From: Grahame Dorrington [REDACTED]
Sent: 12 January 2020 23:08
To: Sian Eggington
Subject: Re: FG 148/19/HH
Attachments: We sent you safe versions of your files; IMG_20200103_0001_NEW.pdf; IMG_20200104_0001_NEW.pdf

From: Sian Eggington
Sent: Friday, January 10, 2020 1:53 PM
To: Grahame Dorrington
Subject: RE: FG 148/19/HH

14C 1

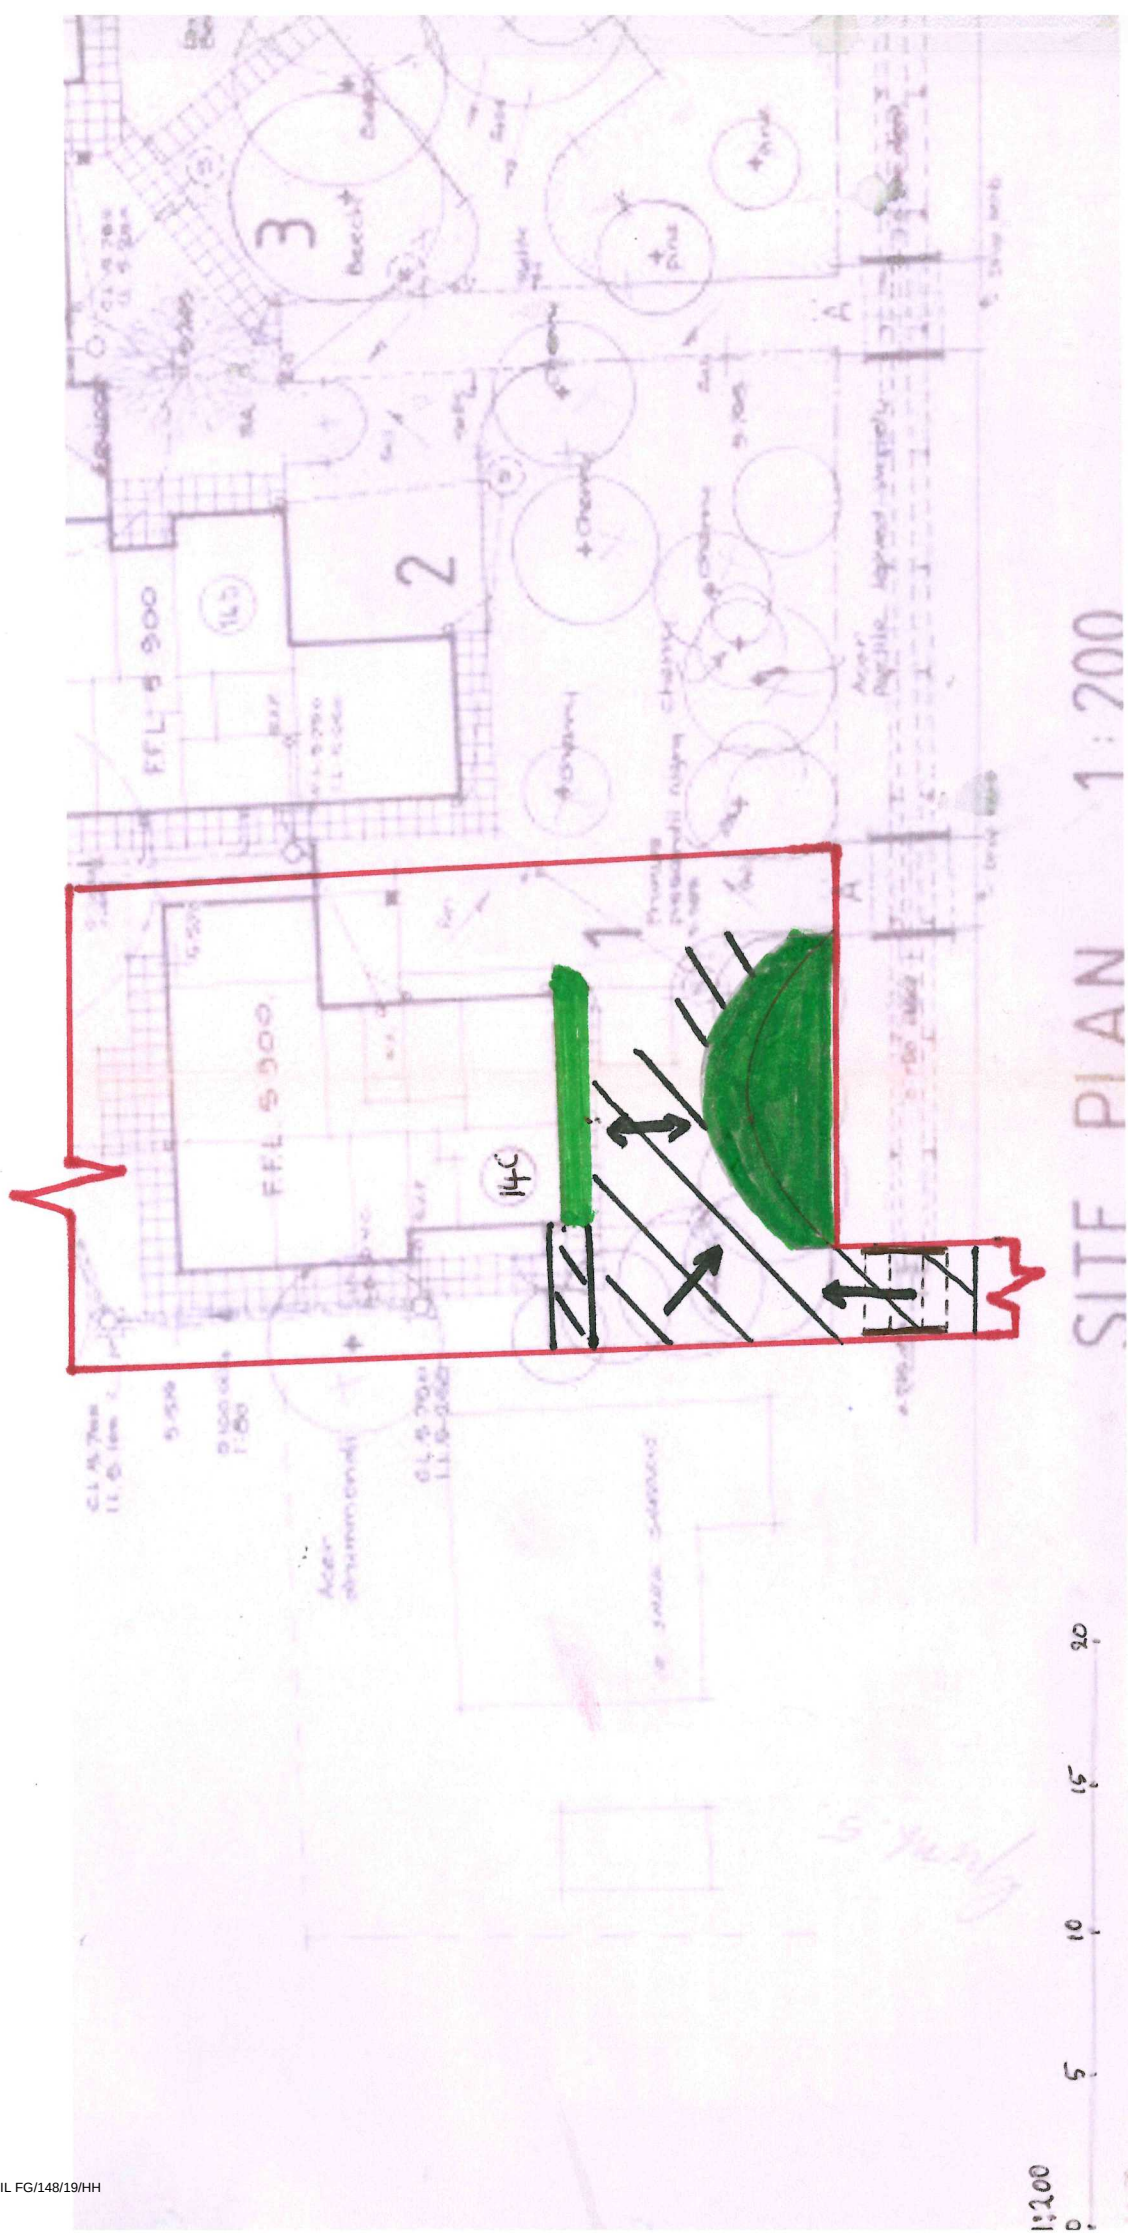
Could you please clarify what you are applying for as you are stating that the kerb does not require any changes but the application is for a second vehicular entrance and the plan indicates a drop kerb? From the location plan it appears there are other properties on the road therefore the splay would still be required and a proposed plan of the new access would be required.

Thank you for your additional information, however the drop kerb plan is still required (please see attached for an example of what this should look like). The plan should also include the visibility splay- West Sussex County Council require that a visibility splay is provided. A splay is formed for a 30 mph speed limit road by measuring from a point 2.4m back from the kerb edge in the centre of the proposed access. A line should then be drawn from either side of this point for 43 m in each direction to the nearside edge of the carriage

way. The splays must intersect land only within the control of the applicant, or within the publicly maintained highway. The distance will increase with the speed limit of the road. If the road is 40 mph speed limit then the distance should be 120 m either side. For speeds above this please contact West Sussex County Council Highways for advice on what would be acceptable. Please contact the council directly with any issues regarding the splay.

The proposal is not for a drop kerb, the kerb is referenced on the plan for information purposes. I have spoken with a transport planner regarding my application.

- 1) The Highway authority will not comment on the proposal because Sark Gardens is a private Road
- 2) If the new entrance is for inbound vehicles only a visibility splay is not required because there will be no sight lines that could be compromised – there is no safety issue that needs to be addressed – other properties are not affected by the proposal.

The proposed plan for the drive has been submitted please see plan 14C1. For clarification the existing access on the eastern side is shown outside the red line but is to be retained

14C2 v2

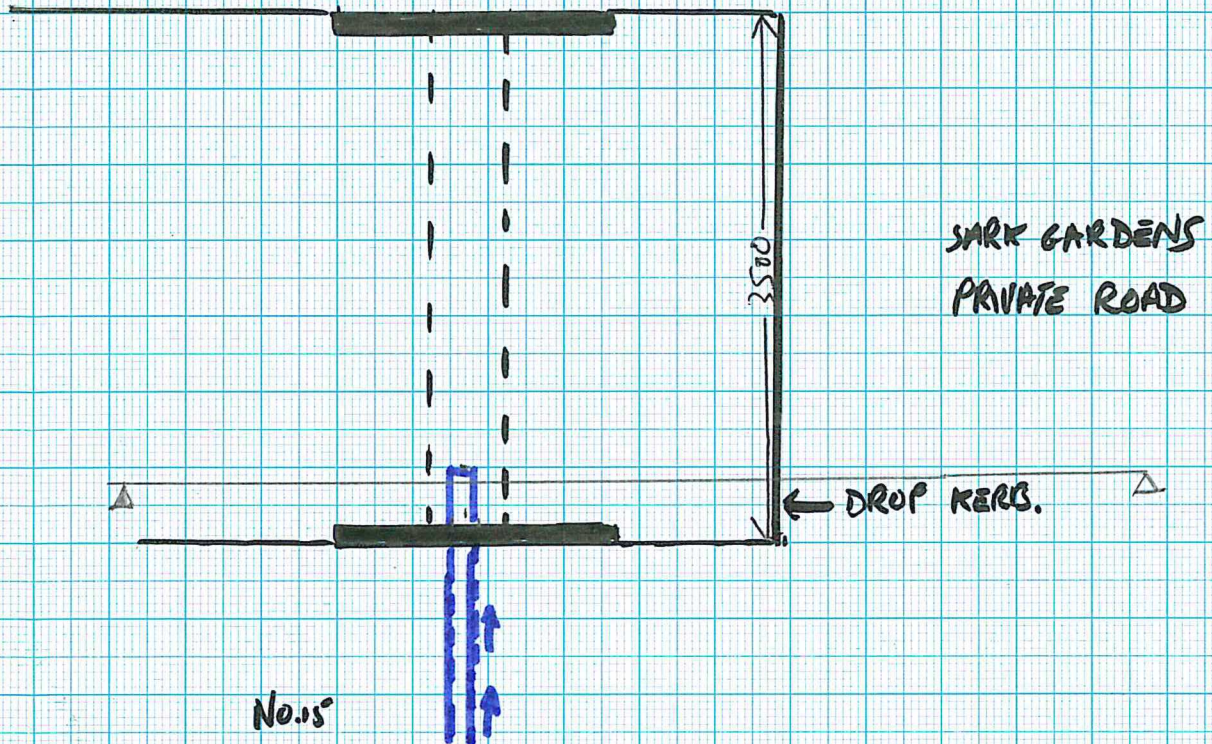
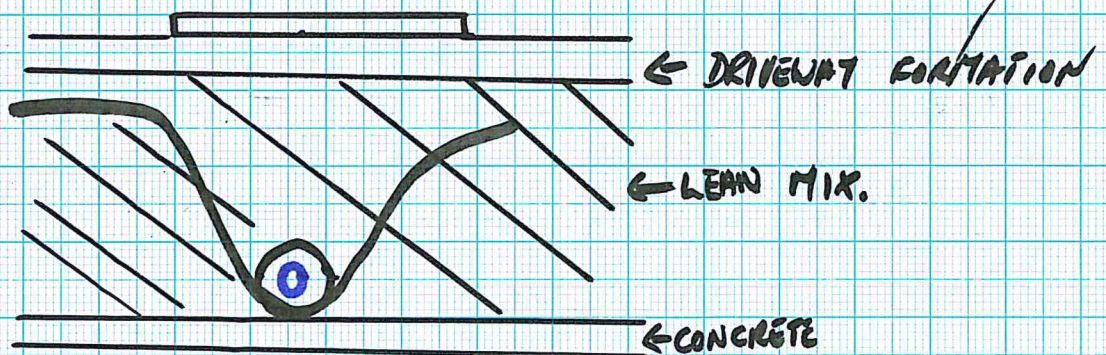
I have just heard back from the council and they have requested elevations of the proposed bridge. Also a photograph of the existing bridge is required. Please see the reply from the council below.

'As it is an in drive, I agree no visibility splay is needed and as it is on a private road we do not need to concern ourselves with the dropped curb. From his planning statement he is applying for driveway itself which incorporates a bridge over the ditch. We will need elevations of what it is going to look like'

I have uploaded a photo of the existing bridge and drawings of two elevations of the proposed bridge for your attention. The West elevation is below ground save for the dwarf wall so could see no point of that drawing.
